## Comments on the Applicant's D1 Submissions

This document sets out the comments by Cambridgeshire County Council (**CCC**) and Fenland District Council (**FDC**) (together, **the Councils**) on the Applicant's Deadline 1 (**D1**) submissions. The tables below set out the document in question that the Councils are commenting on, together with the relevant paragraph or reference number.

**Figure 8.1**  
**Air quality survey monitoring locations**

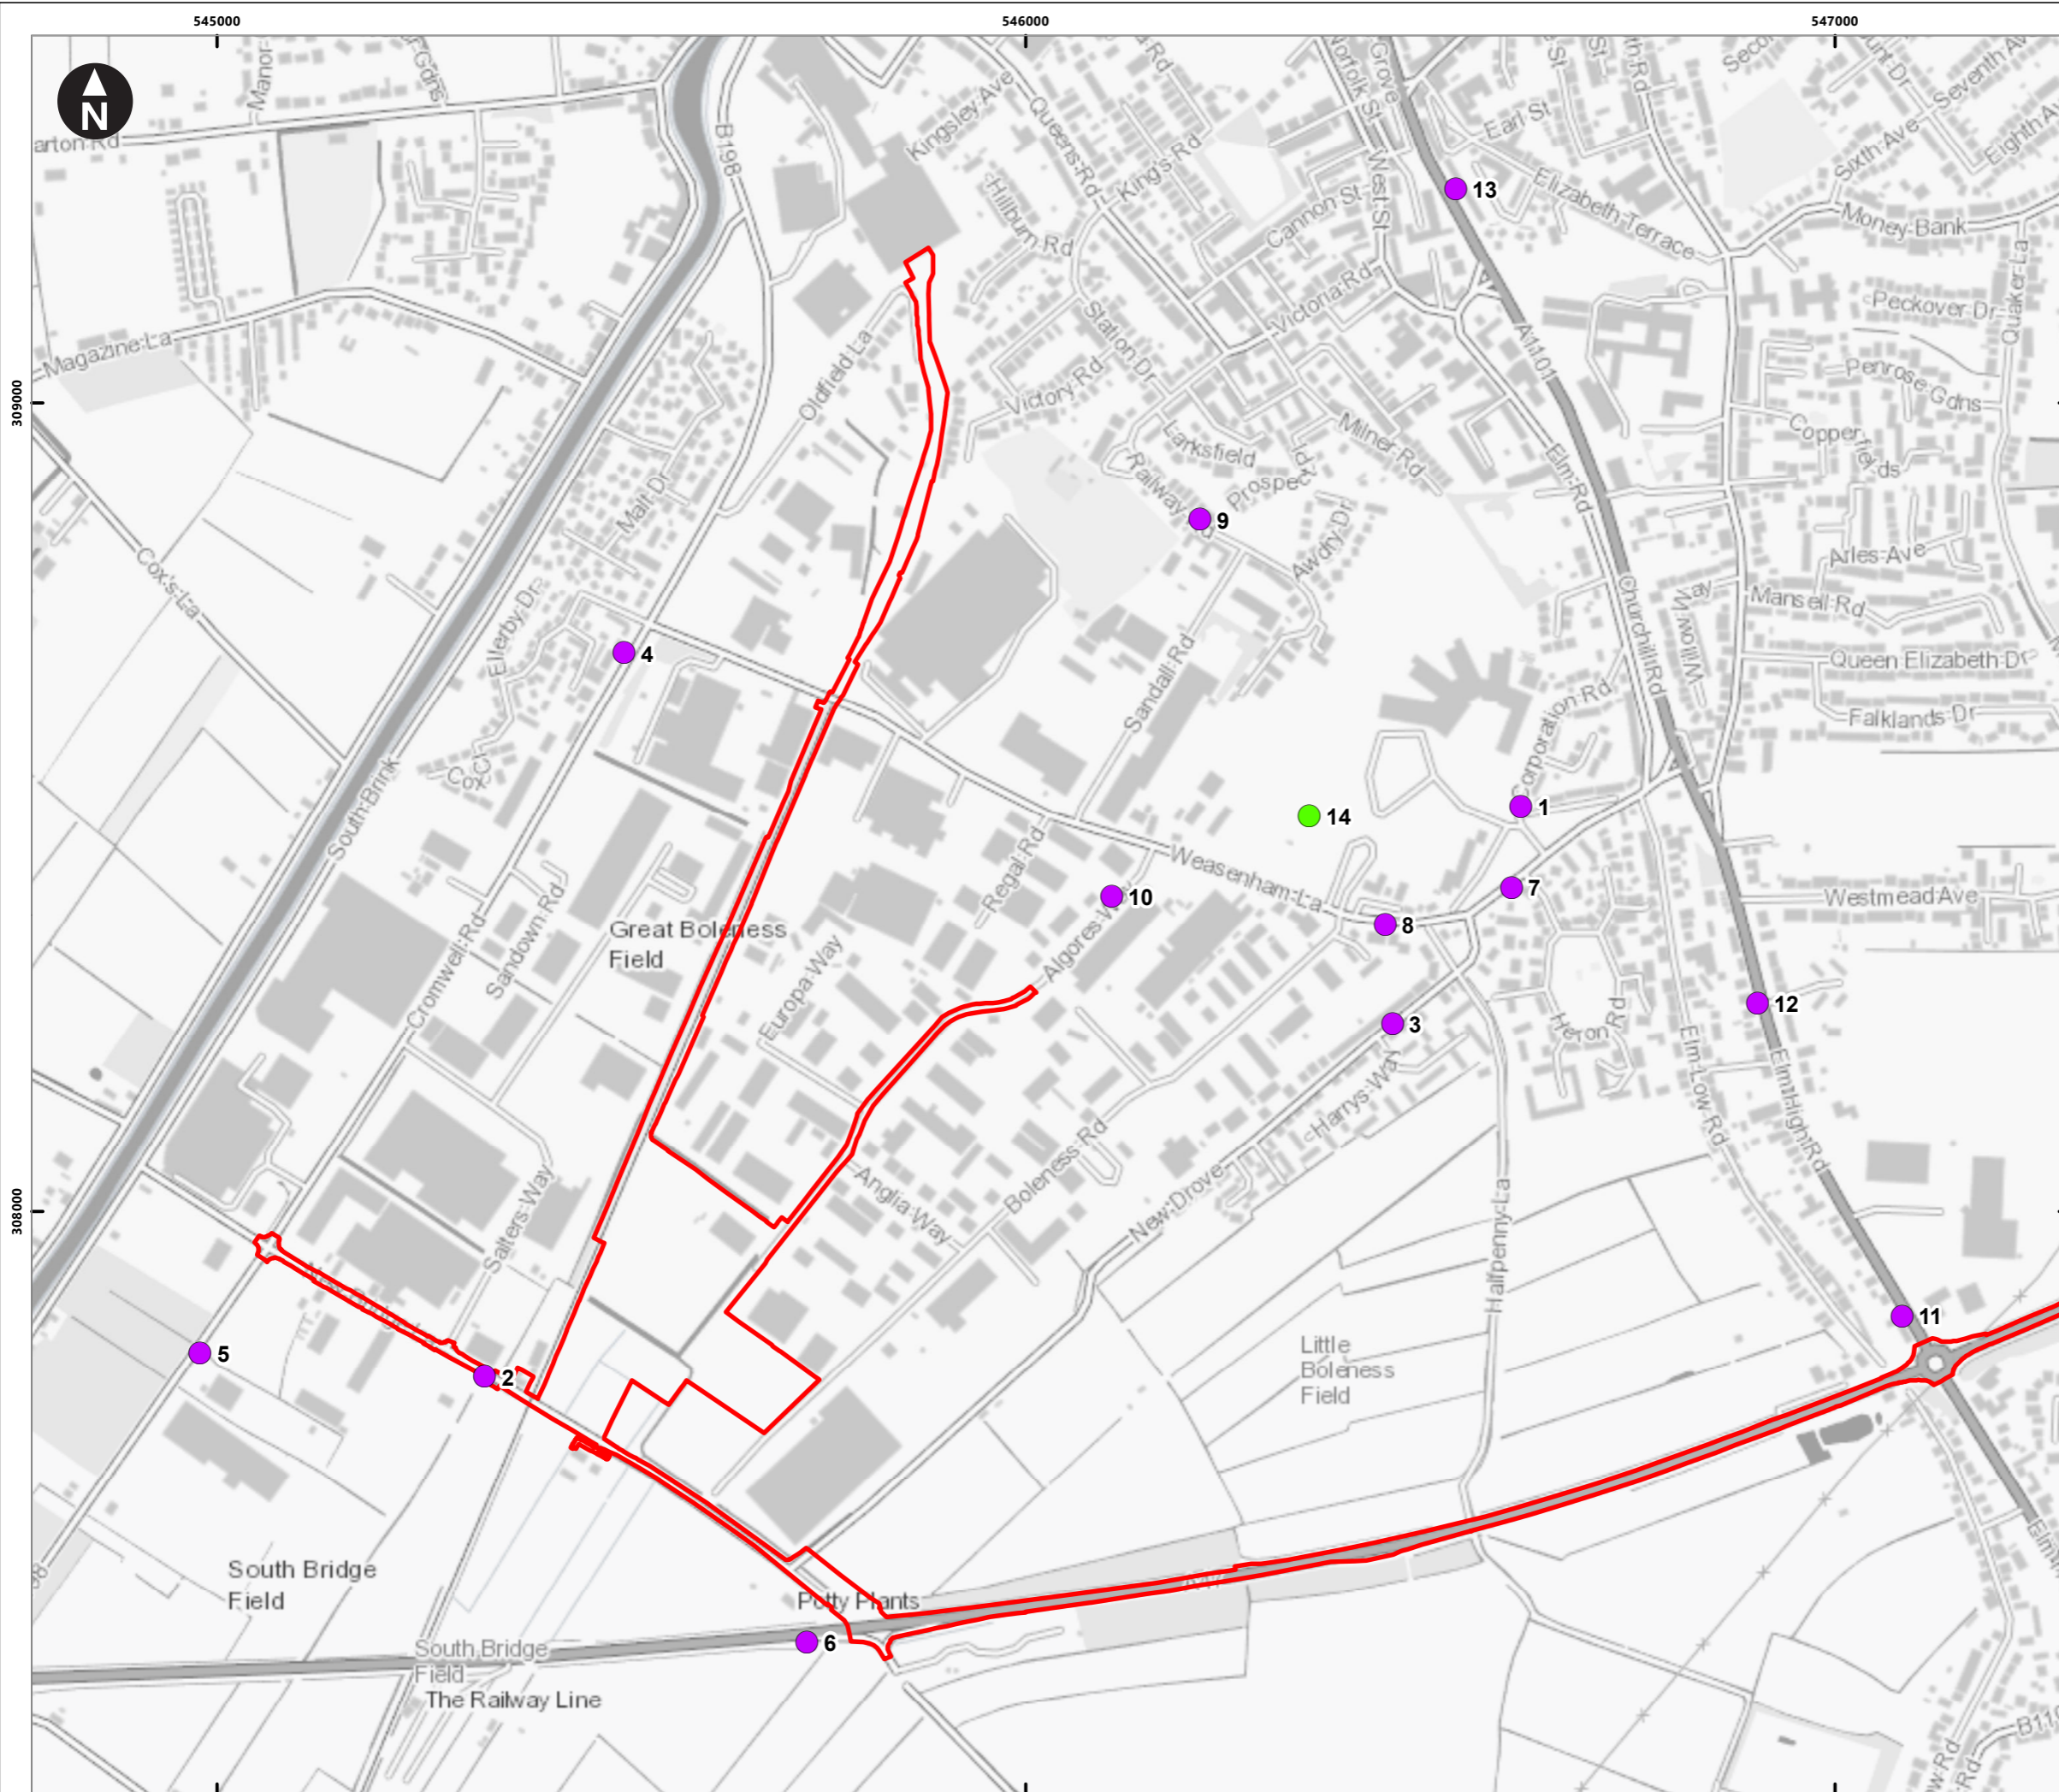
Topic	Paragraph Number	Councils' Comment
Demolition and Construction	General	The Councils request that the monitoring strategy also includes a monitoring strategy focused at the demolition and construction phase, in line with the Construction Management Plan objectives.
Location of Diffusion Tube and Continuous monitoring	General	This document includes the location of Diffusion Tube and Continuous monitoring for the operational period of the development. The Councils do not object to these locations, although seek to confirm them on completion of specific information regarding transport routes and equipment.
Local Air Quality Management	General	FDC would like to ensure that there is support for Local Air Quality Management, and request information is made available for the Annual Air Quality Screening Review and any Air Quality Action Planning if required.
Further Information	General	The Councils request that this document provides more detailed information including the availability of data to the HLAs, interpretation of data, and process for the notification of exceedances. If an exceedance is identified, the Councils would like this document to outline the commitment for source identification, resolution and emission reduction associated with this installation and its associated activities.

Table 3.1 Nearest sensitive Receptors

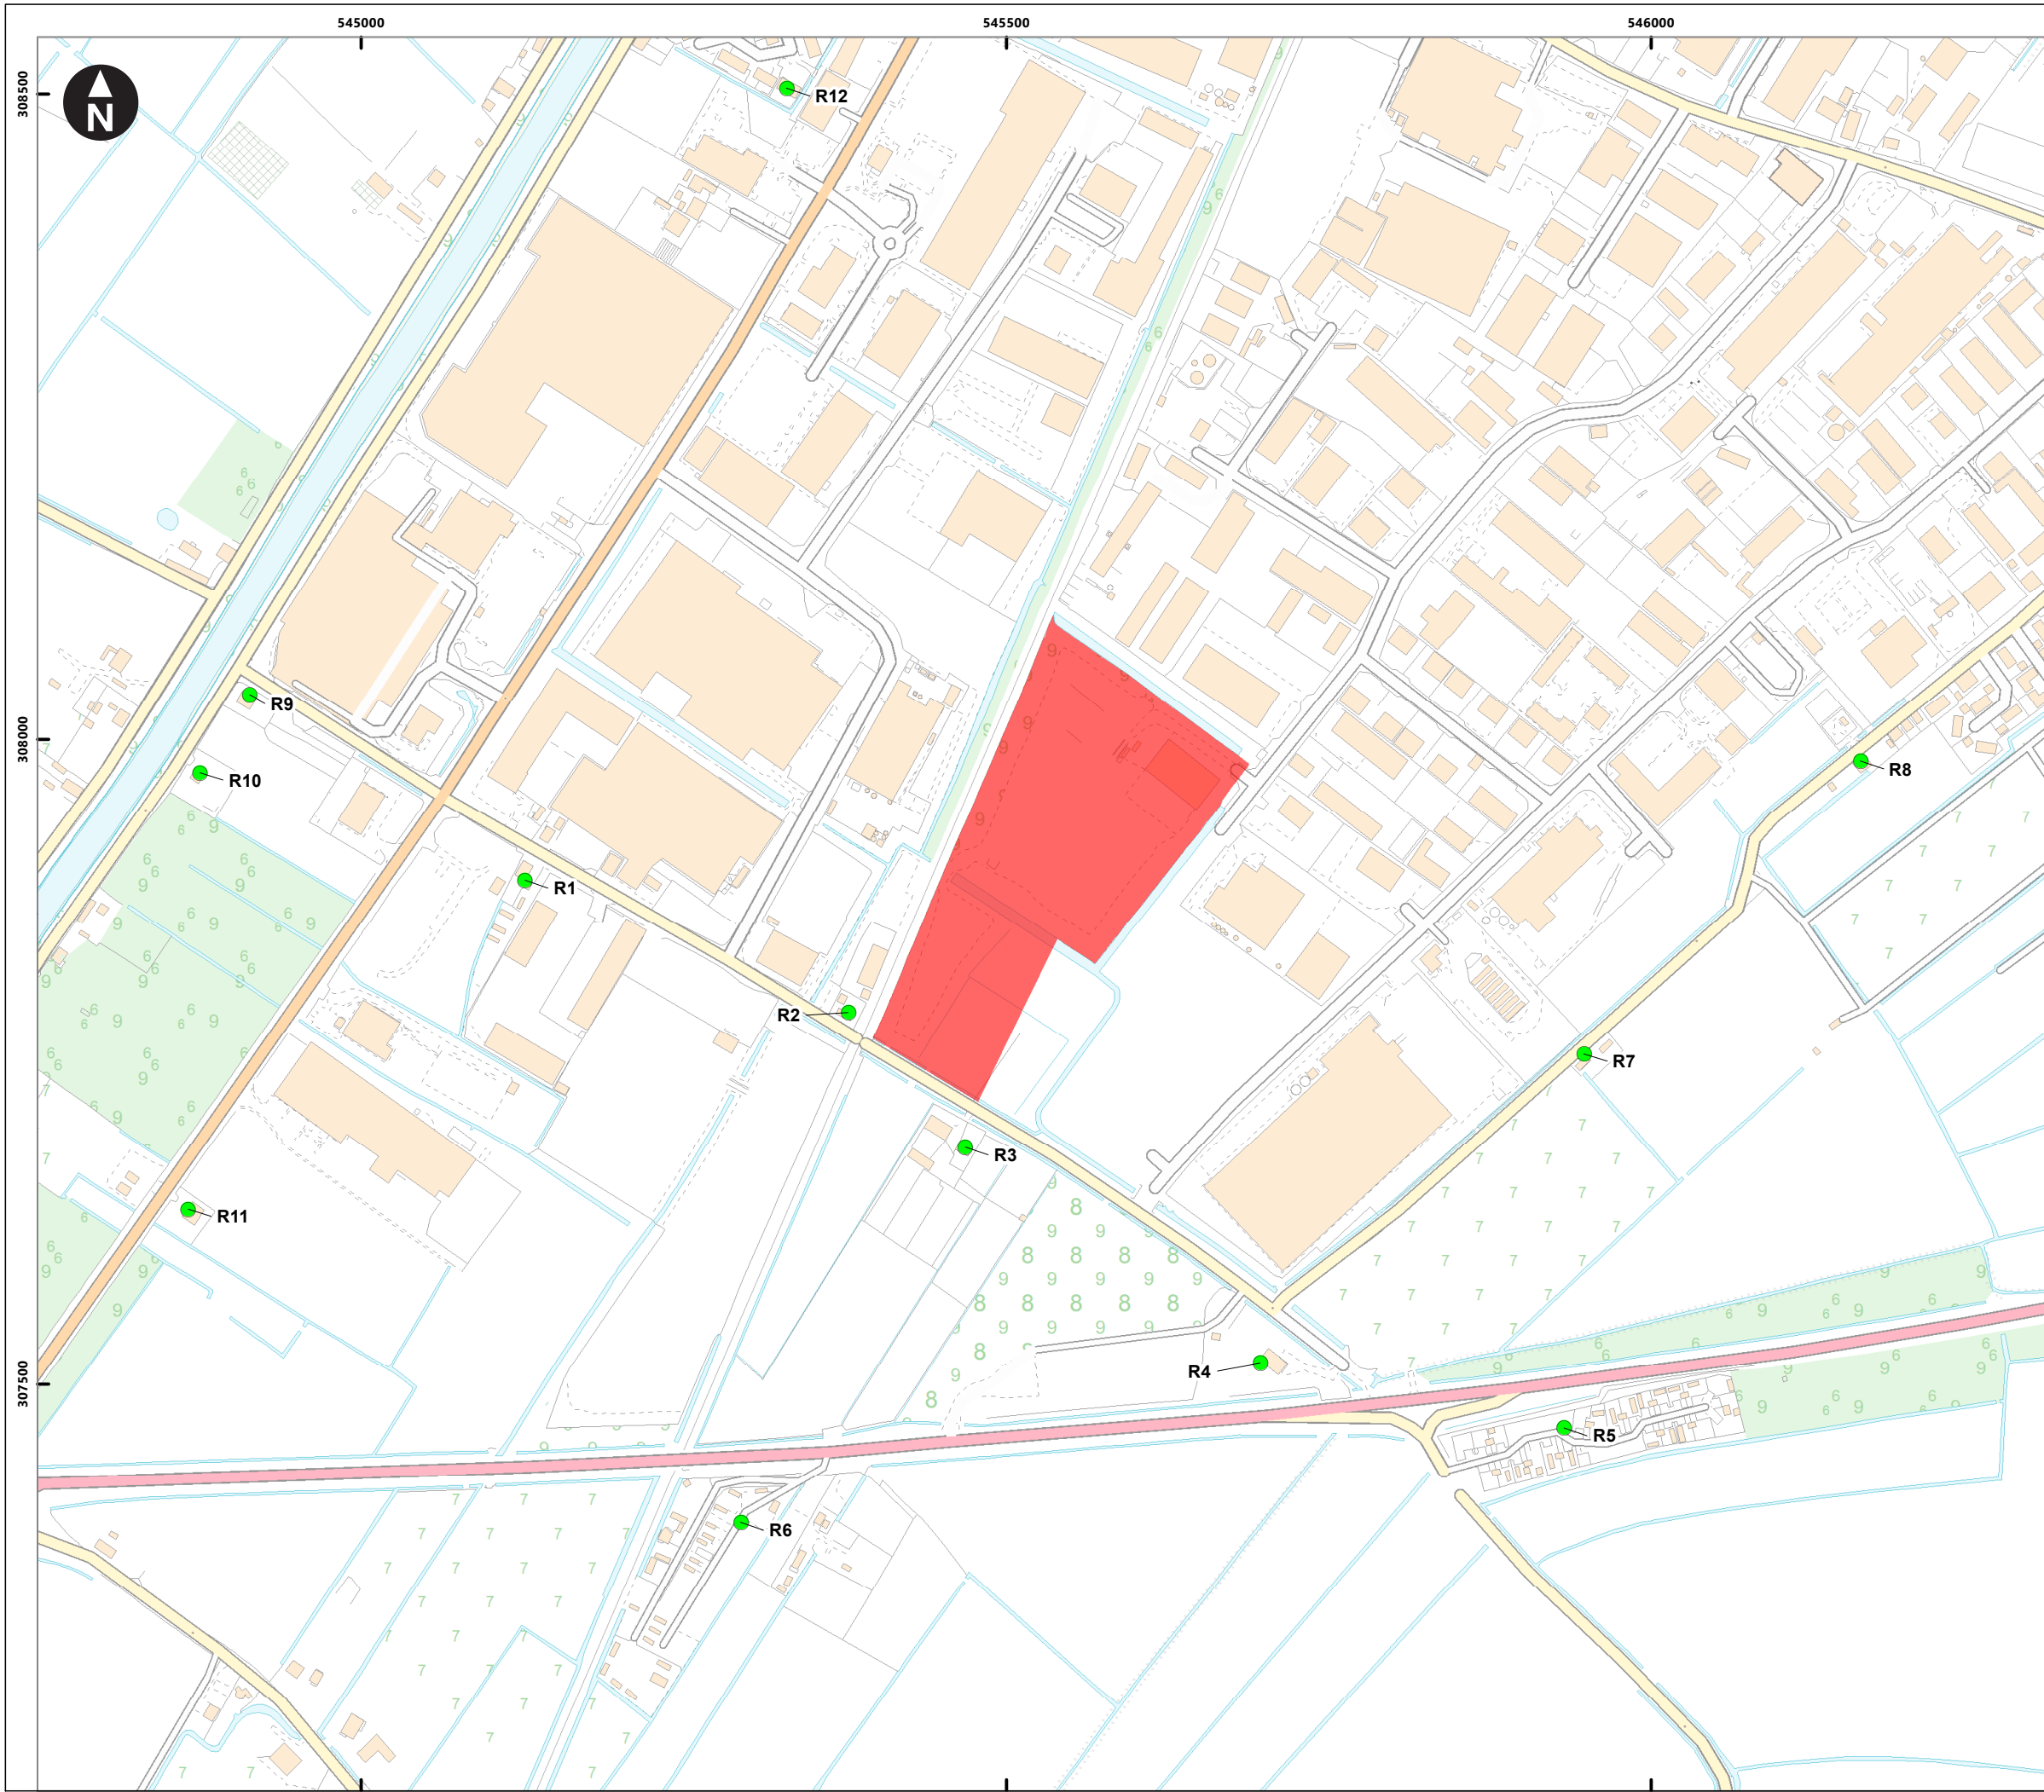
Topic	Paragraph Number	Councils' Comment
Exclusion of R2	Table 4.1	The Councils would like to highlight that predicted operational noise effects from the permitted installation has excluded R2. Although it is understood that it is the intention for this development to purchase the property, and therefore it will no longer be a receptor. Until a time when this property is no longer a residential property, R2 is still a valid receptor and should be included in the table.
Acoustic fence at 10 New Bridge Lane	5.1.2.	In addition to the location of an acoustic fence at 10 New Bridge Lane, the design features of any acoustic fence including should be detailed in the report including its height, materials of construction and noise attenuation calculations. It should be demonstrated that the fence will be sufficient to achieve the outcome specified in Table 4.1 after mitigation. If the owners or

occupiers of 10 New Bridge Lane are not agreeable to this mitigation measure, an alternative option(s) should be provided.
--	--	--
